From: Holly Erdman
Sent: Wednesday, February 13, 2019 4:06 PM
To: Chelsea Benner
Subject: RE: Notice of Application CB-19-00001

Please review the following Boundary Line Parcel Combination application submitted by Peter Ackroyd (CB-19-00001). Any comments need to be submitted by 5pm on February 14th. Please let me know if you have any questions.

LOCATION OF EXISTING
STRUCTURE

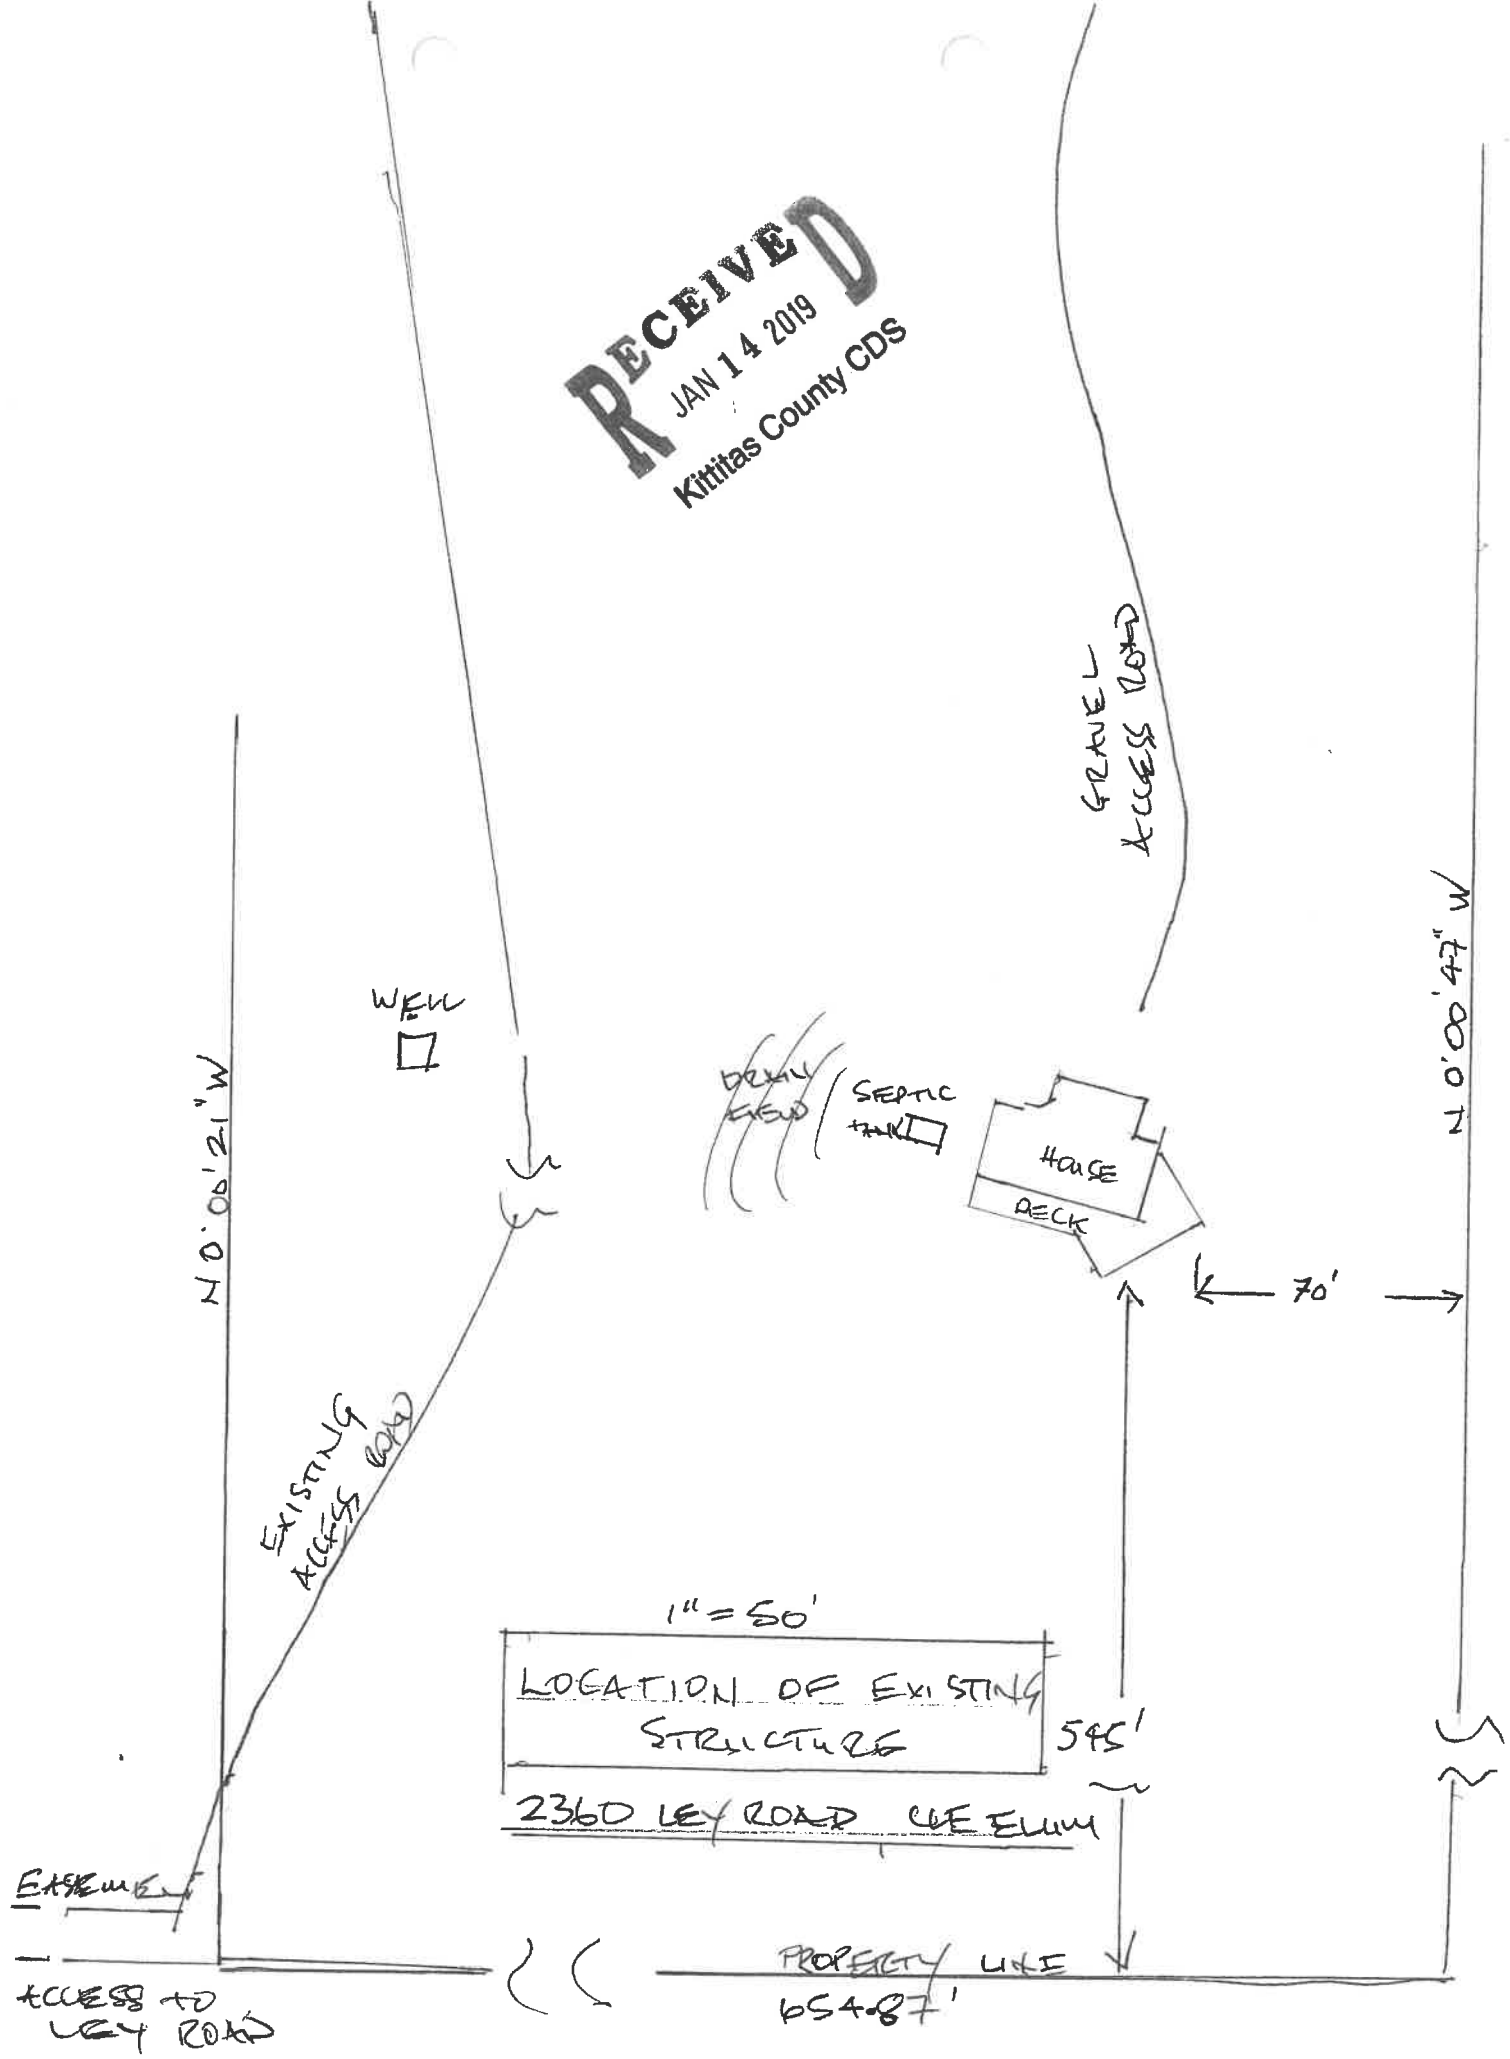
The only reason I asked for the distance that the well is from the property line is because the well looks like it is inside of the 1 acre square with the house and the septic system. I thought I understood that the rest of the parcels were being combined except for this one remaining acre. Did I understand correctly or did I miss something?

Thank you for this opportunity to comment. On the site plan provided, the distance from the property line to the well is unclear. A scale is provided but following that scale, the well doesn't meet the required 50 foot property line setback. Public health needs to know the distance the well is from the proposed property line.

The 1 acre piece is only for tax purposes, it is truly not its own parcel.

This is a parcel combination so there are no lot lines being moved. Do you still need to know the well setback?
Thank you!
